From: Amanda Scholes on behalf of Planning.Responses
Sent: 17 November 2021 08:11
To: Hannah Riddle
Subject: FW: *EXTERNAL: FW: FP/248/20/PL - Landscaping Plans
Attachments: CHANGING FACILITIES PLAN AND ELEVATIONS rev J.pdf; BDWS23254_11C-Sheet2.pdf; BDWS23254_11C-Sheet1.pdf

- Drawing No. BDWS23254 11 Rev. C Hard and Soft Landscape Proposals (Sheet 1).
- Drawing No. BDWS23254 11 Rev. C Hard and Soft Landscape Proposals (Sheet 2).
- Drawing No. CFB/180220/HT-CFB Rev. J Changing Facilities Building

As the surface water drainage proposals have changed to remove the open attenuation basin, which is not required, and to extend the existing swale to obtain the required storage, please could you amend the landscaping plans:

drawing no: BDWS23254 11 Sheet 2

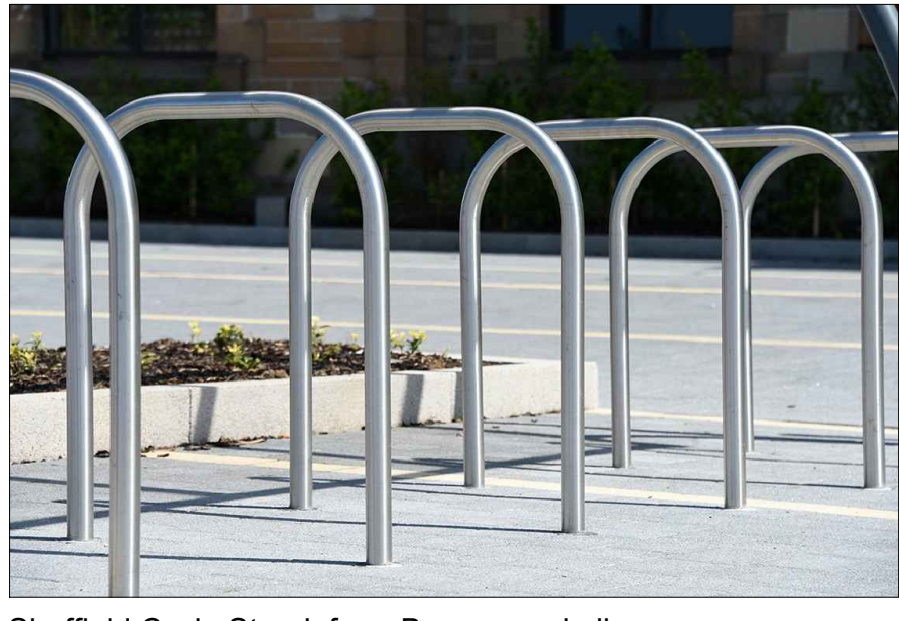
- Drawing No. BDWS23254 11 Rev. B - Hard and Soft Landscape Proposals (Sheet 1).
- Drawing No. BDWS23254 11 Rev. B - Hard and Soft Landscape Proposals (Sheet 2).

Please find attached revised landscape plans (rev C).
